From: [REDACTED]
Sent: [REDACTED]
To: Iqraa Malik
Subject: RE: Request for further information R/244/20/HH
Attachments: We sent you safe versions of your files; Existing Plan.pdf

SITE PLAN 1:500

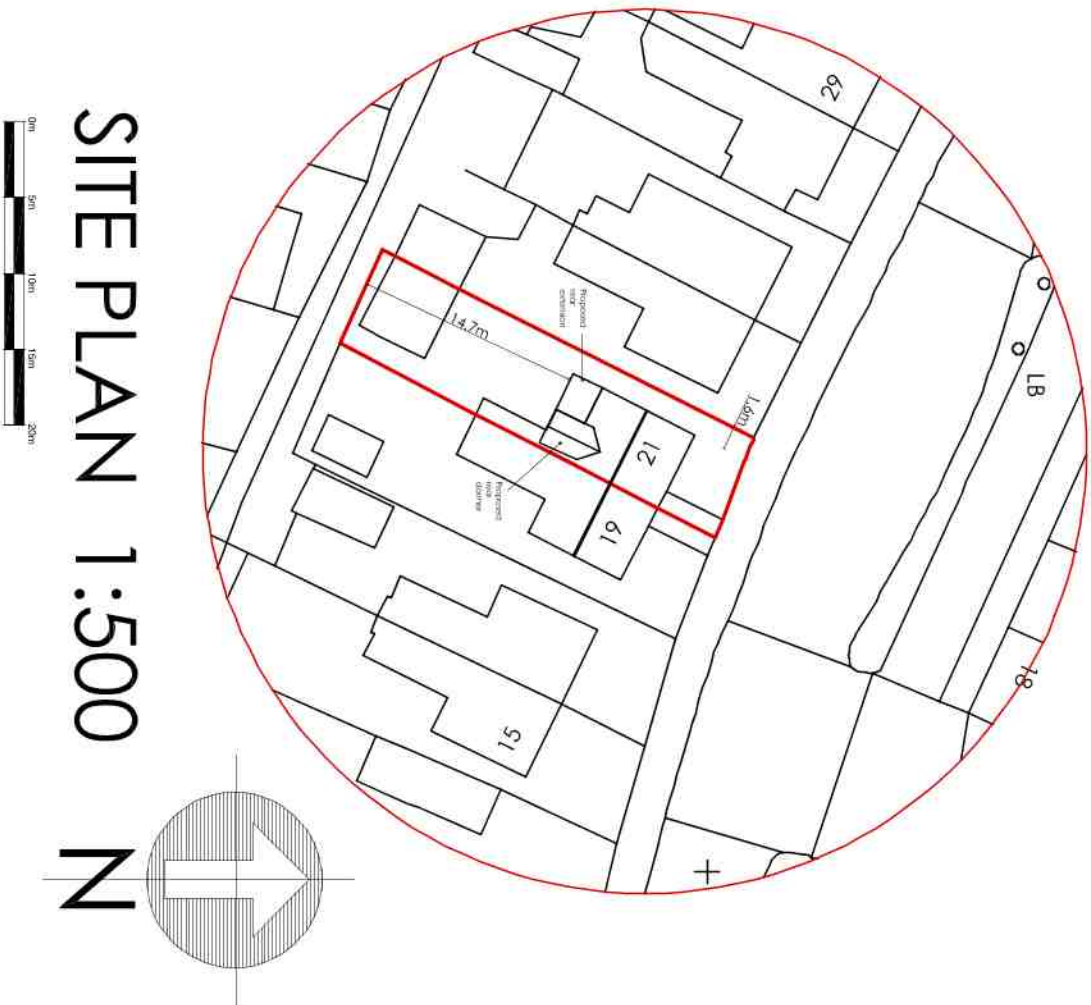
Please add the dimension to the side boundary, neighbouring 23 Worthing Road on the block plan.

Please find attached the revised plan as requested.
